January 15, 2024

Re: **Kendall Auto Group Auto Storage Yard - PA 23020**
IECO No. 20-1092

The project referenced above is revised in response to the review comments dated September 26, 2023. The review comments are numbered on the letter and have been addressed in *italics* as follows:

SHEET 51

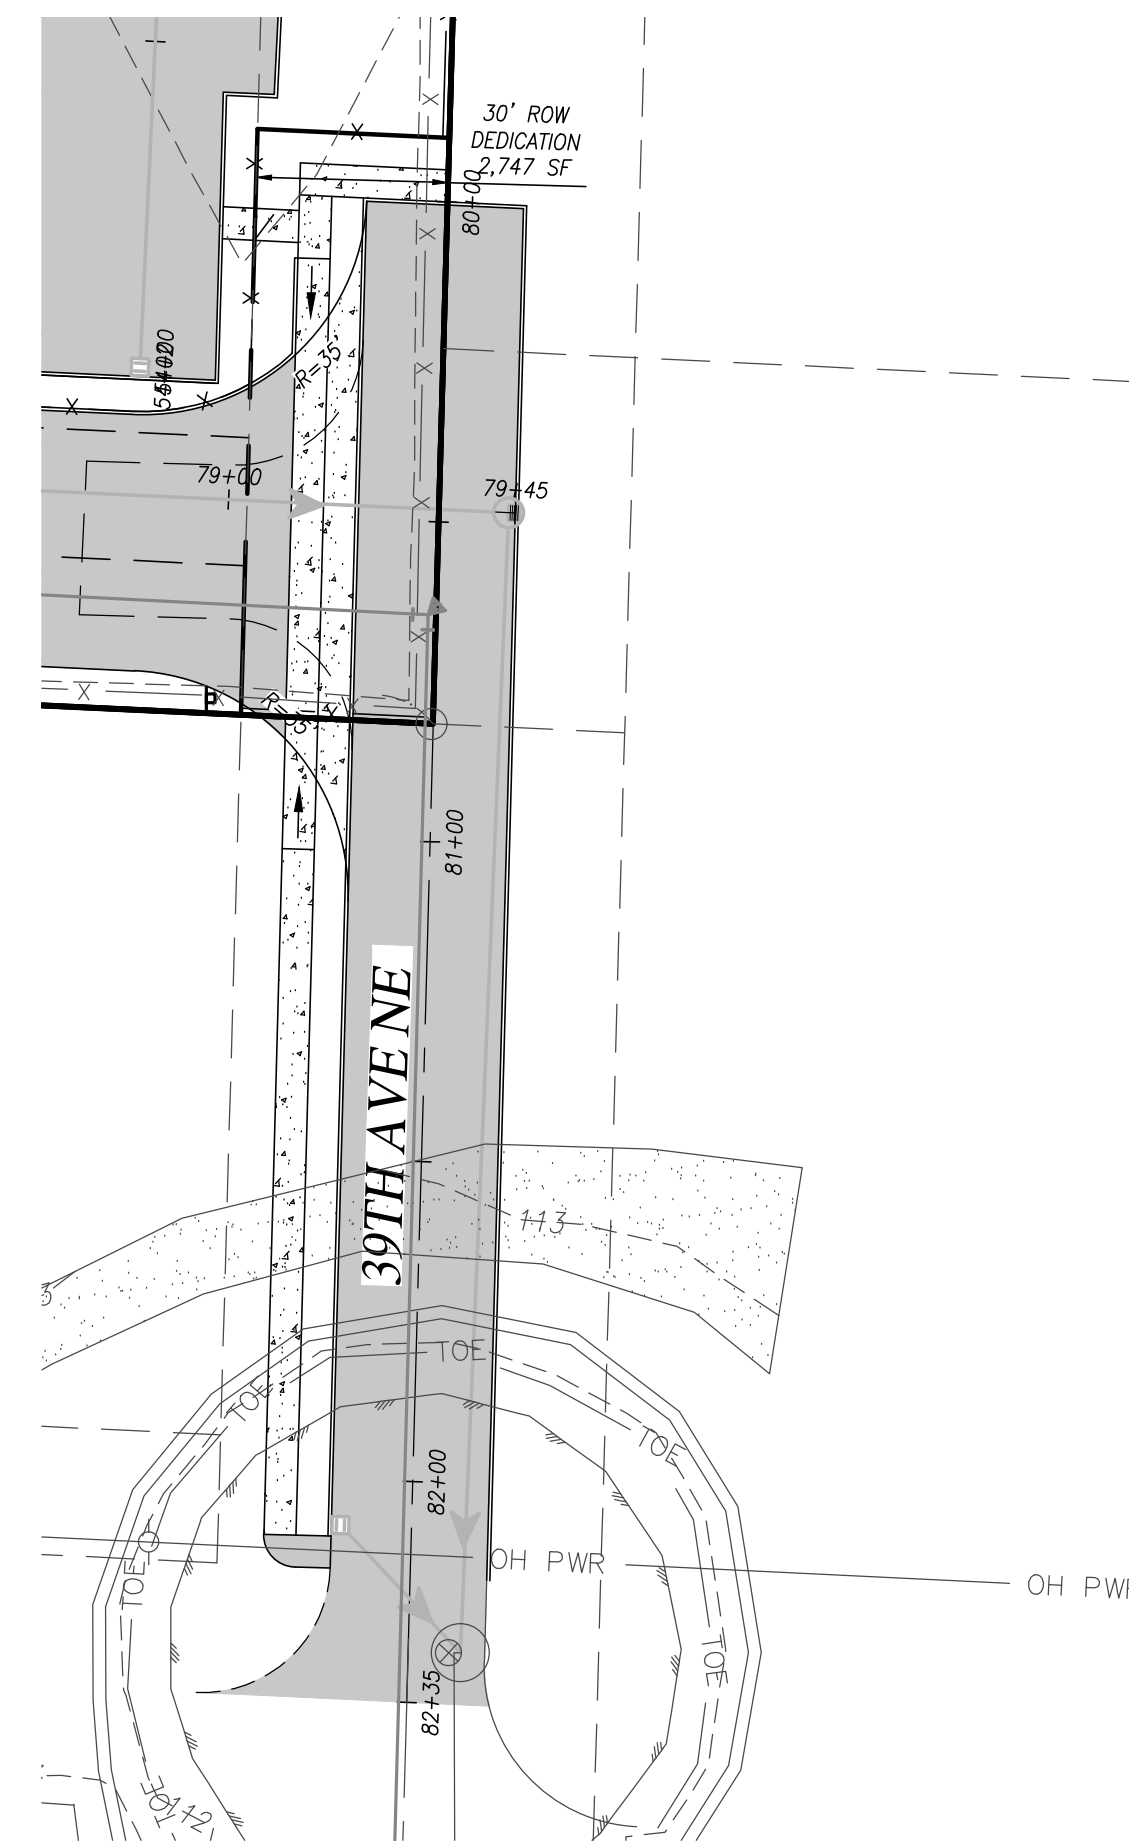
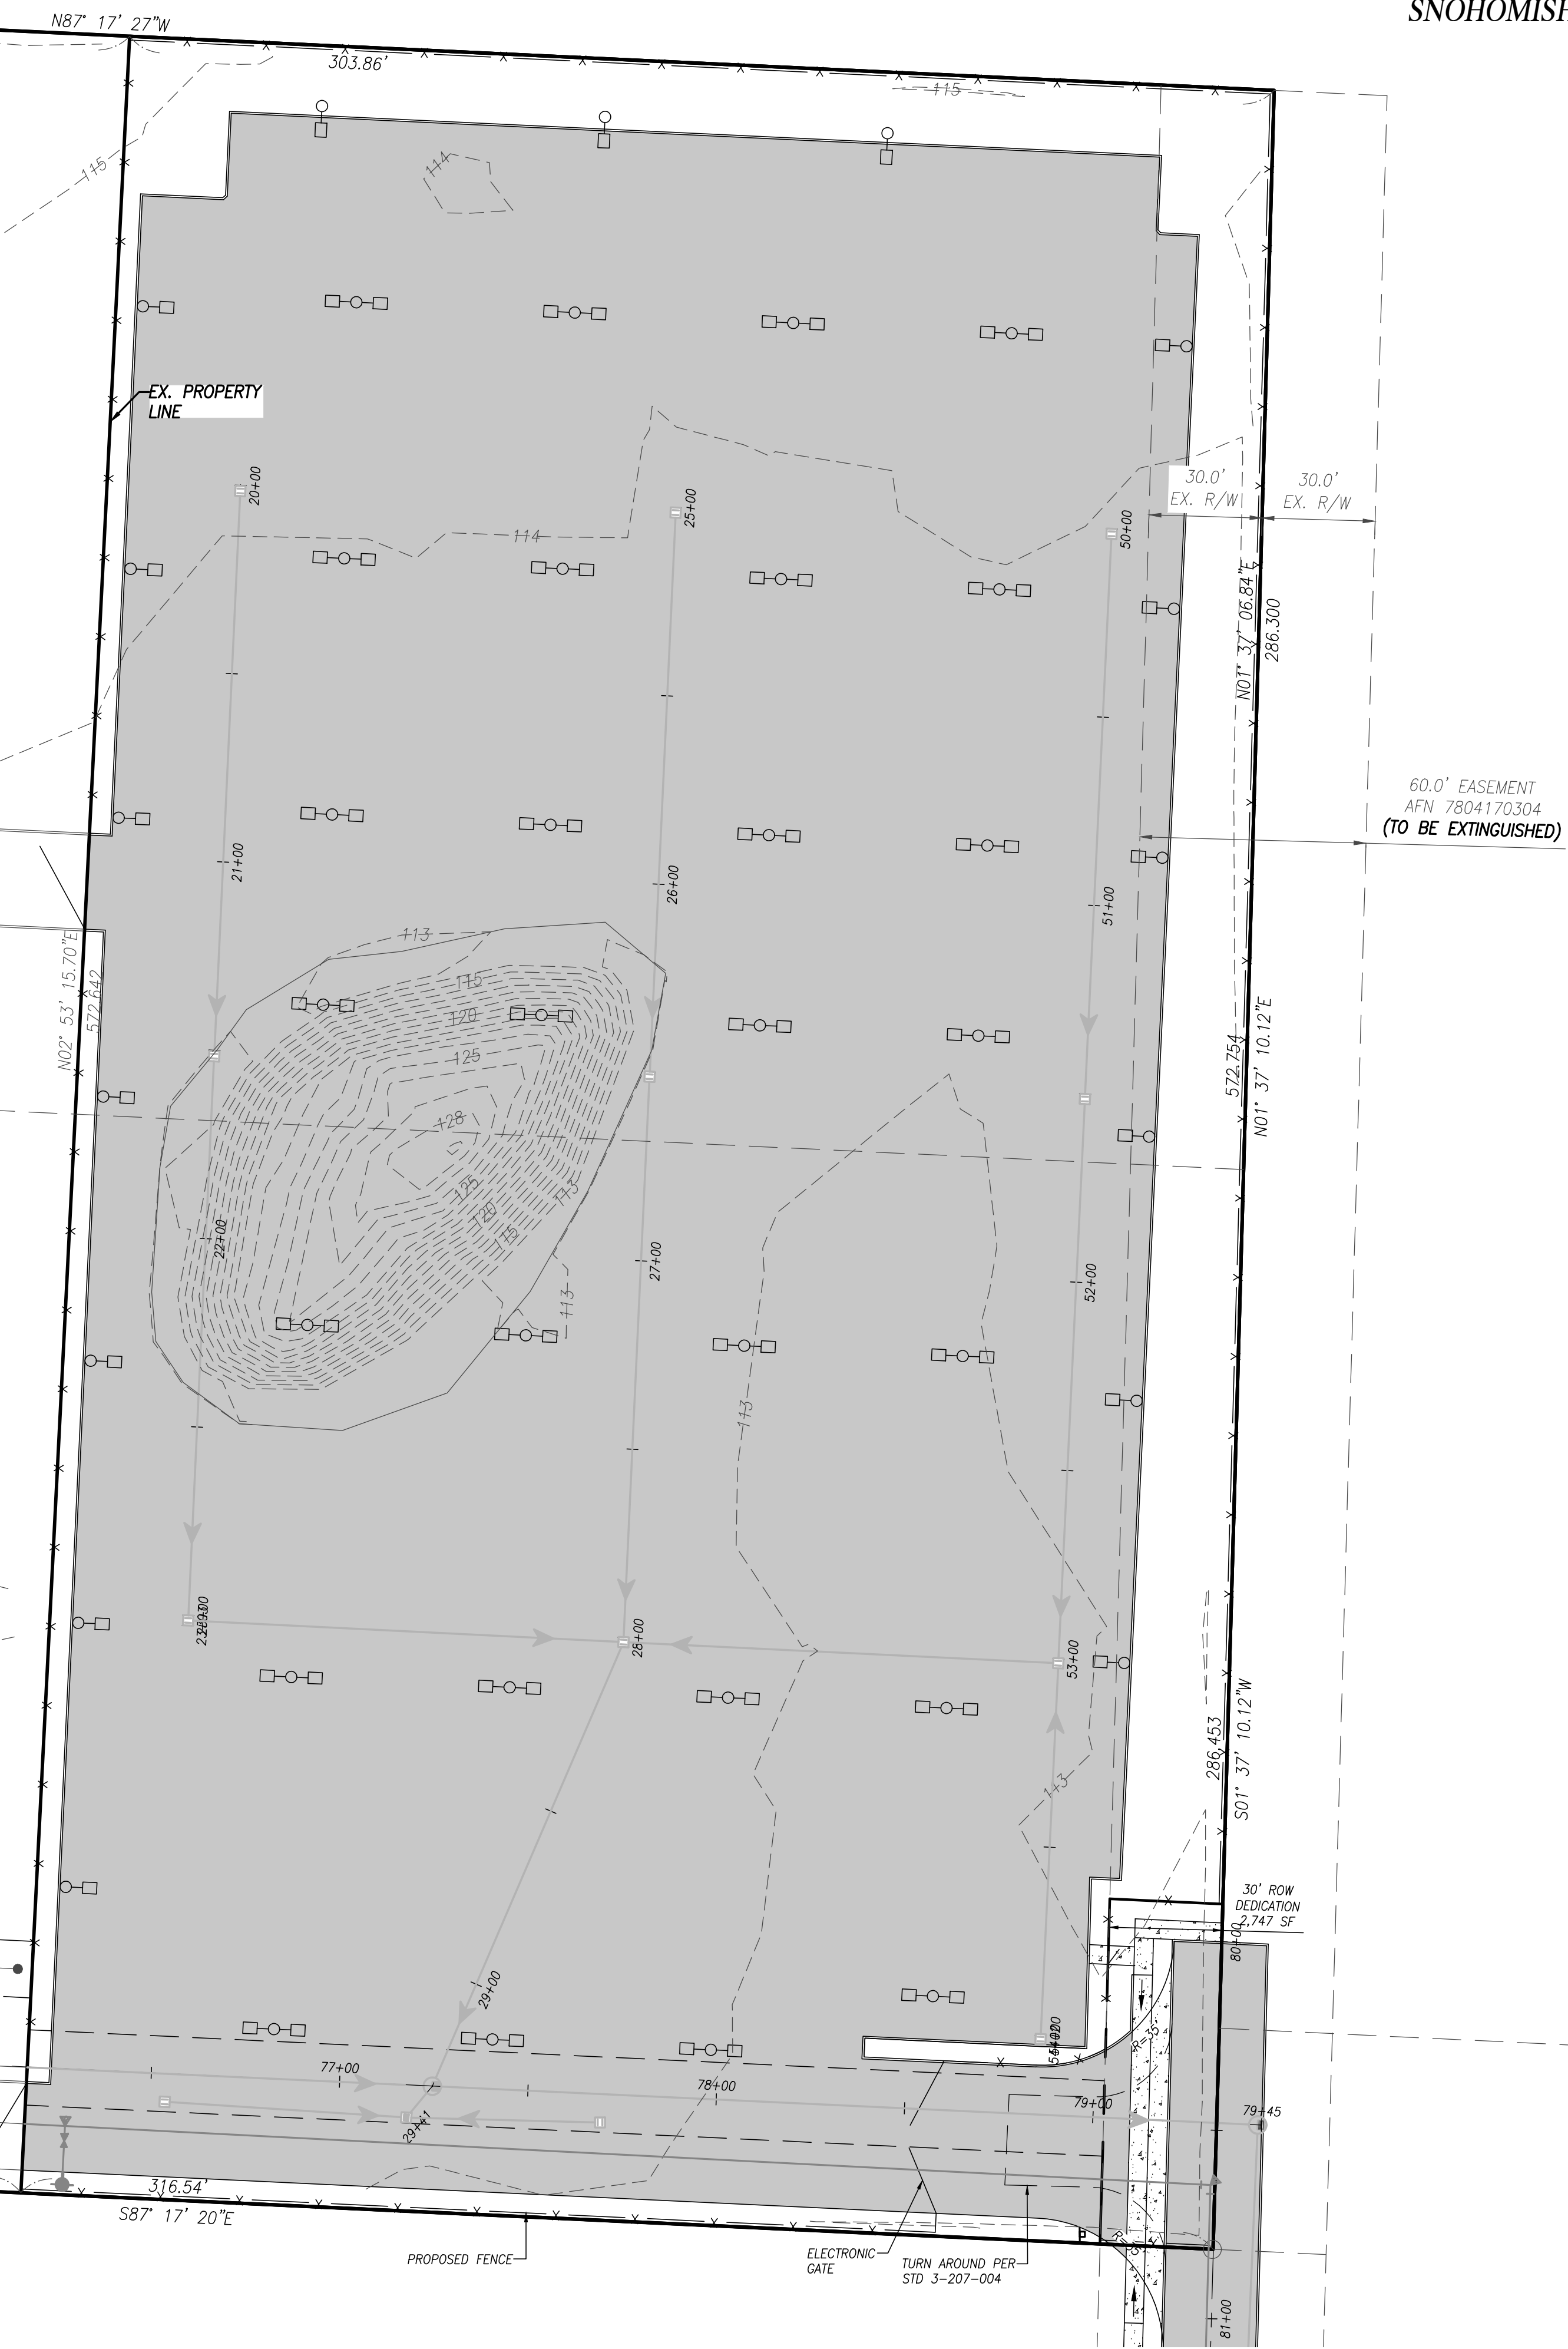
5. The site plan shall be amended, as follows:
 - a. Provide impervious surface calculations demonstrating compliance with the 85% maximum impervious surface allowance.

Please refer to impervious surface calculations in C1.
